Planning reference: 23/11308

Site location: 23 Green Lane, Fordingbridge, SP6 1HU

Proposal: Construction of 4 x residential units; access alterations and parking.
Demolition of existing outbuilding and annex containing residential accommodation.

Consultation response: Objection

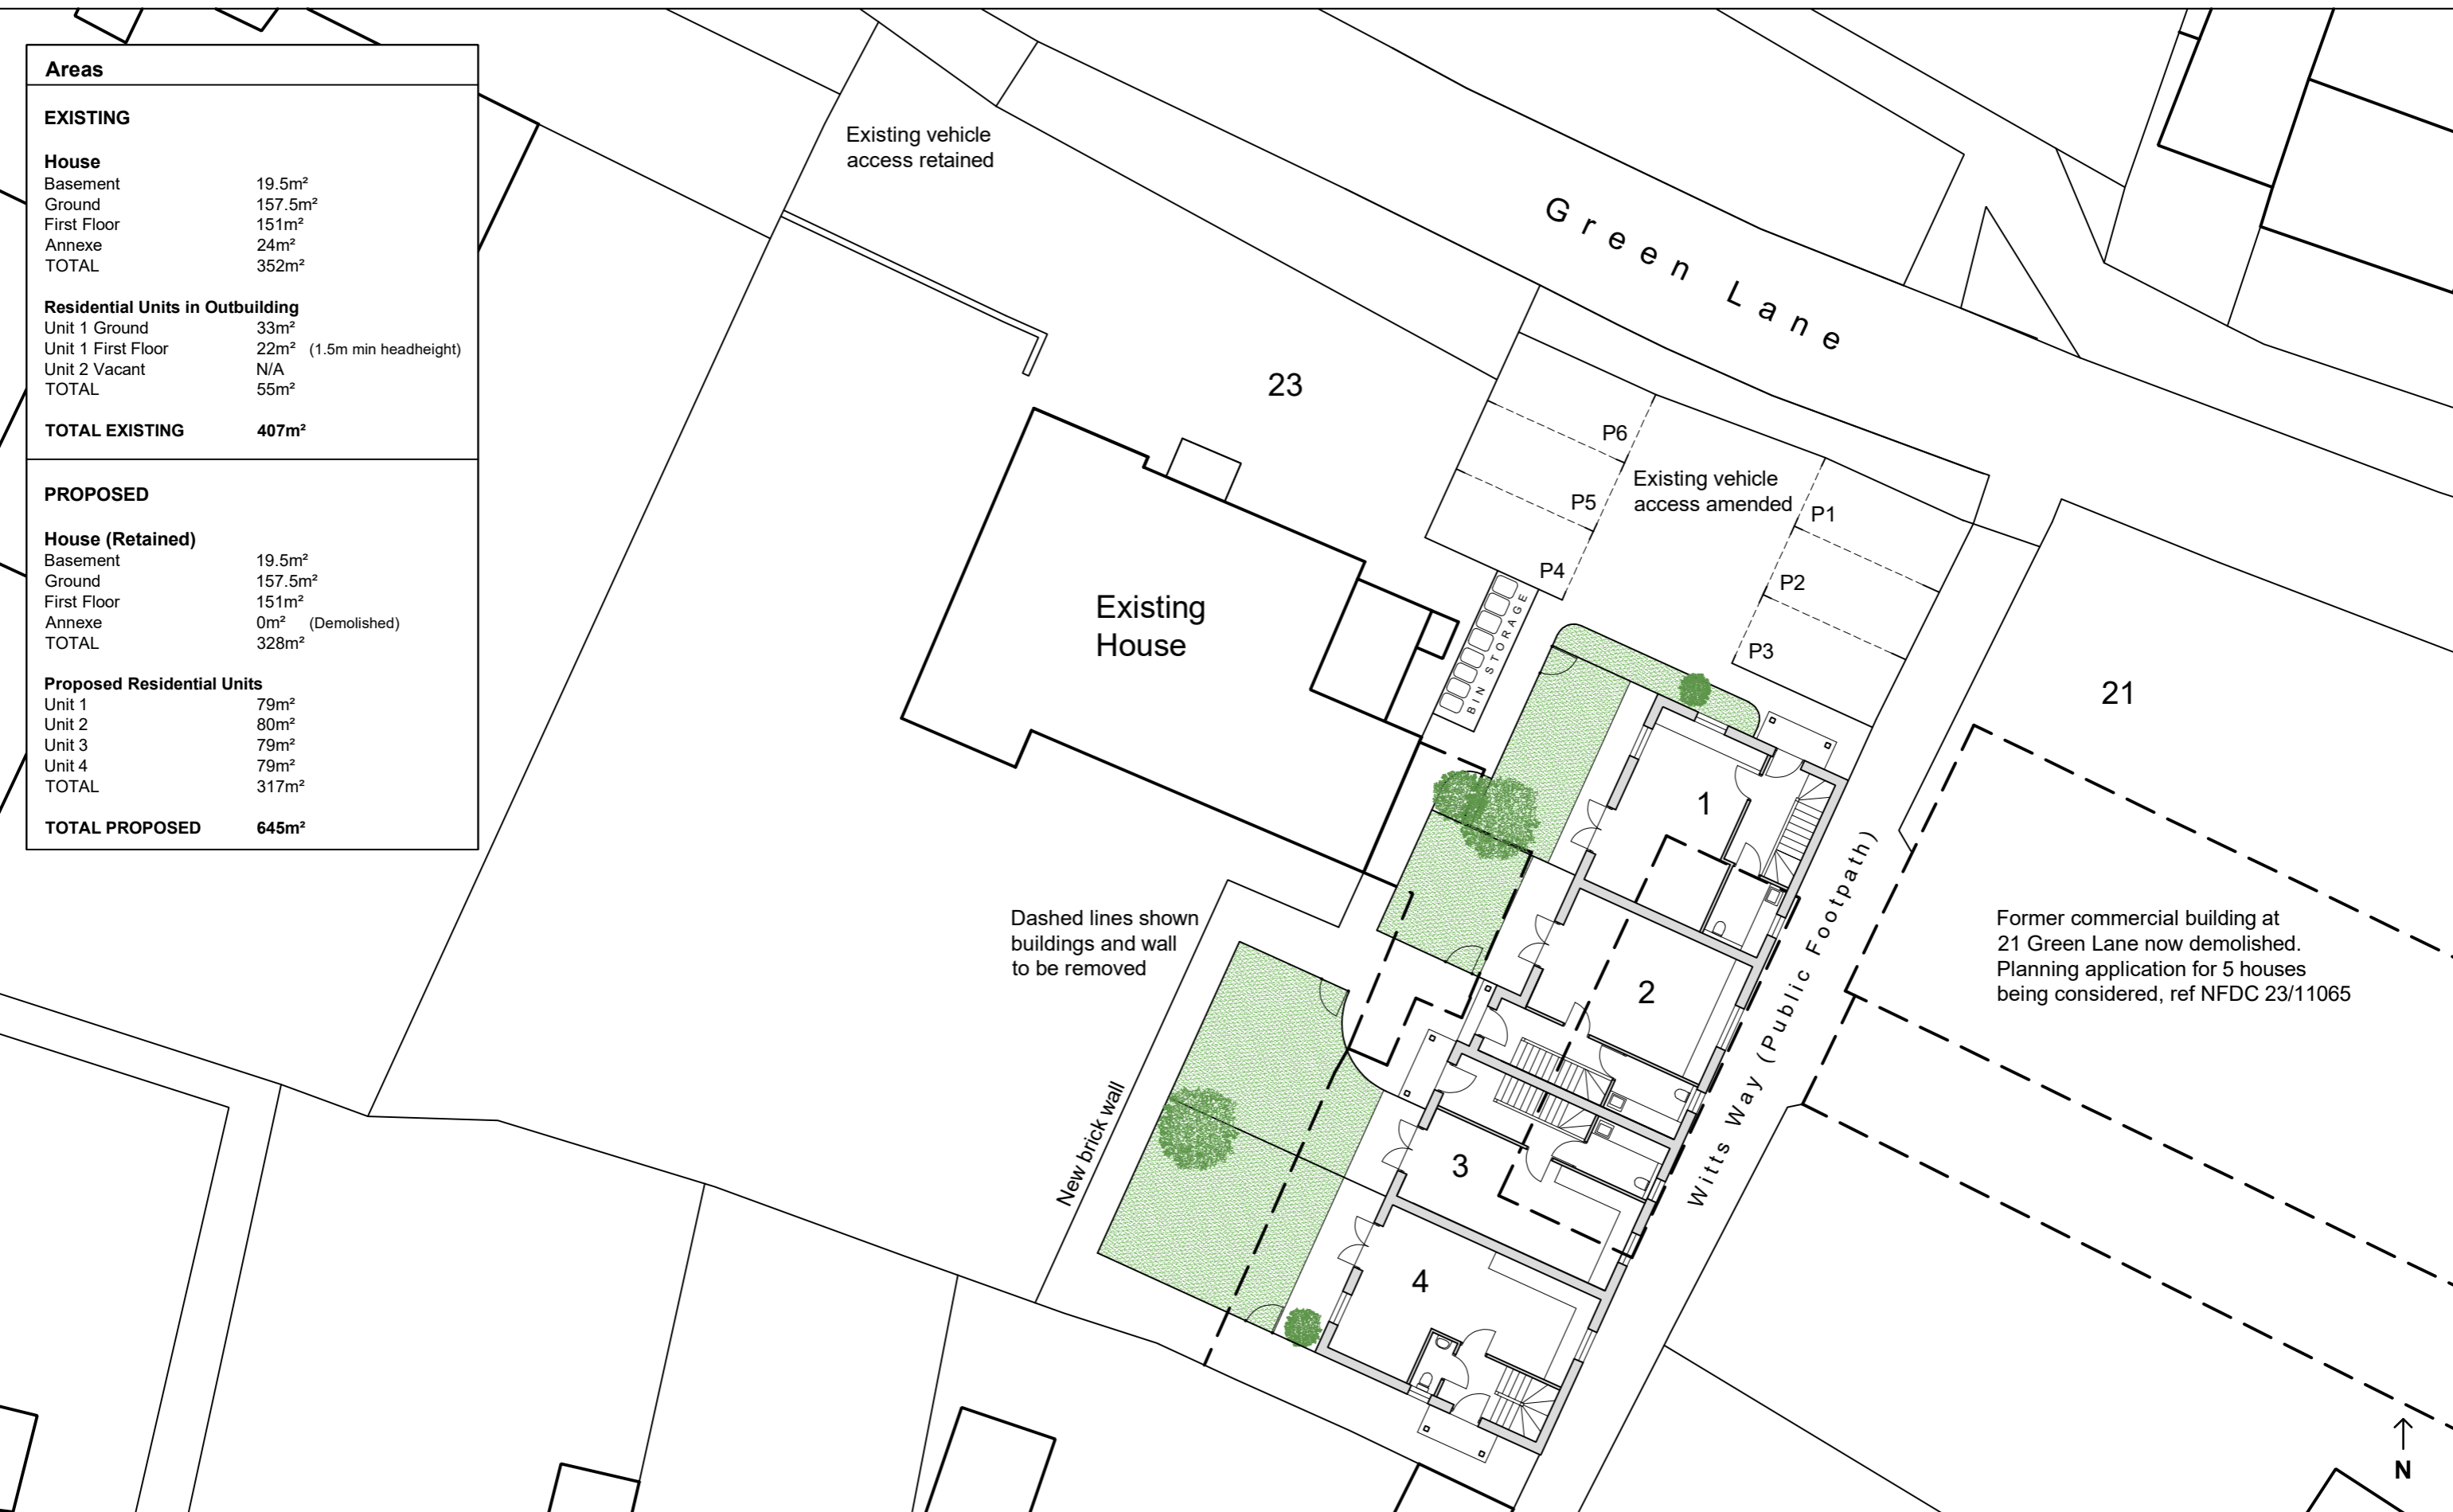
Though the new Proposed Site Plan does not now show a proposed footway connection to FP91, the Design and Access Statement (DAS) page 8 para. 4 states, "A second pedestrian access will also be provided for the new properties from the adjoining public path." Clarification is required and, should a footway connection still be proposed, they are strongly advised to refer to the Service's comments and advice on this matter in its response to application 22/11141.

Proposed Ground Floor Plan

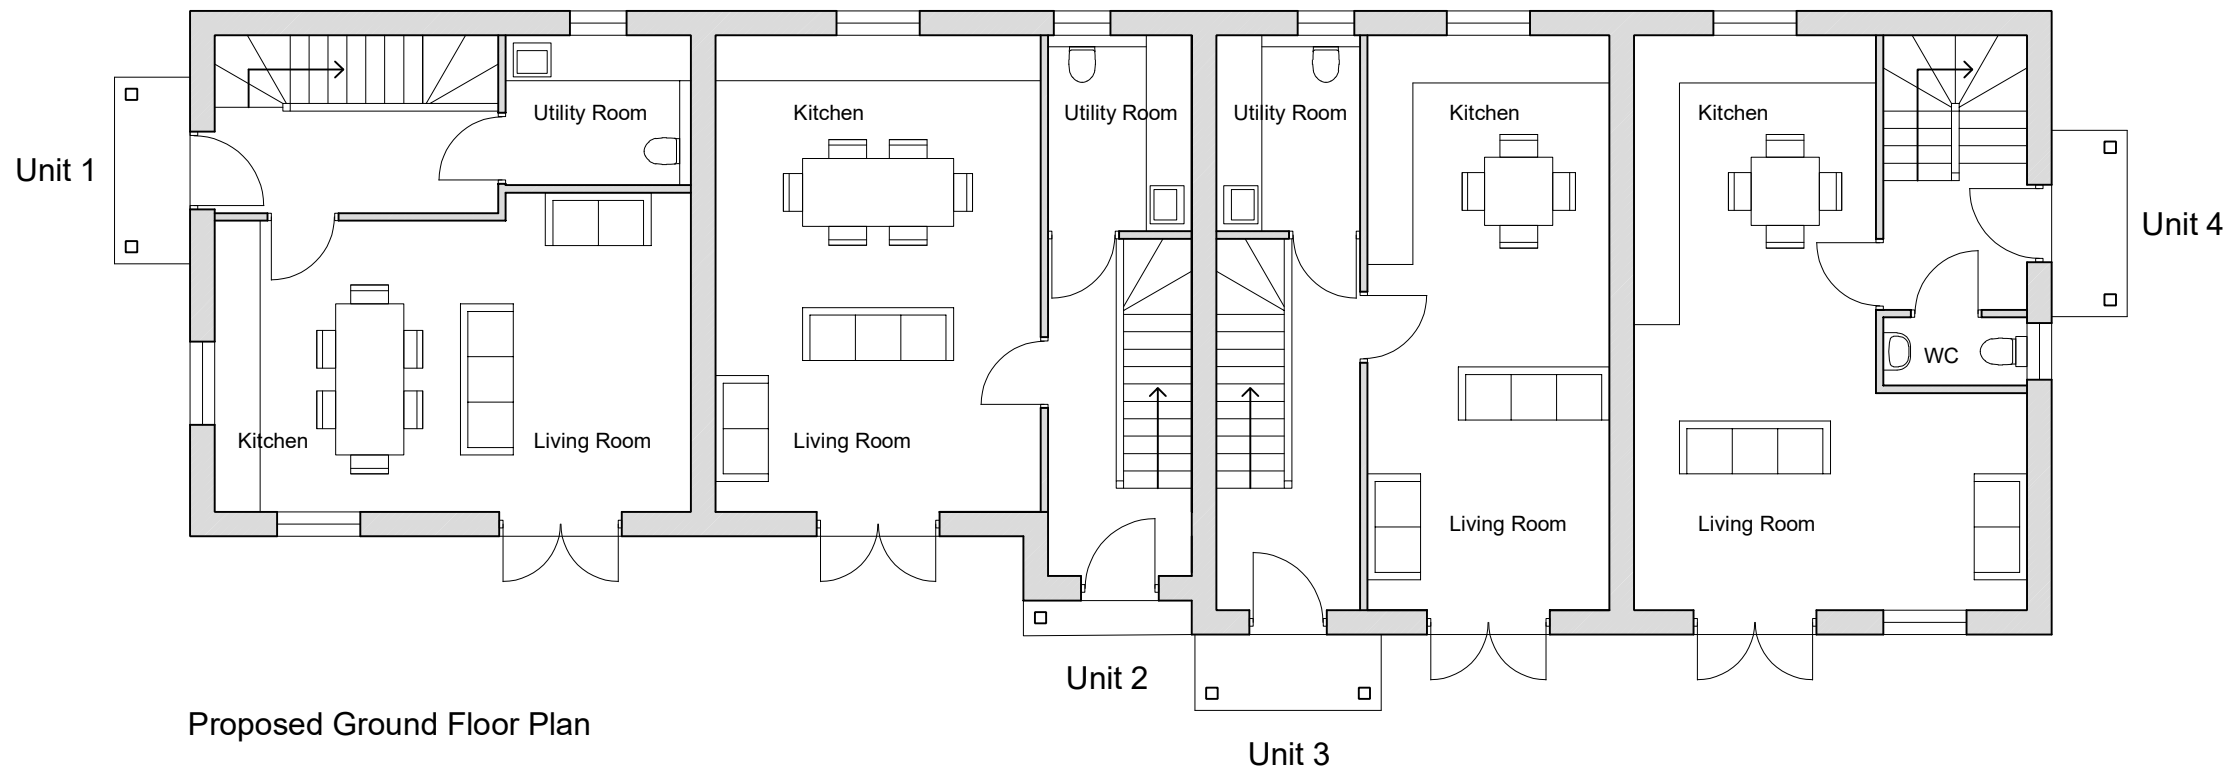
The plans submitted with this application do not resolve the Service's concerns about the overhanging roof eaves and siting of various windows on the building's eastern boundary and the applicant should refer to the Service's previous comments on these issues.
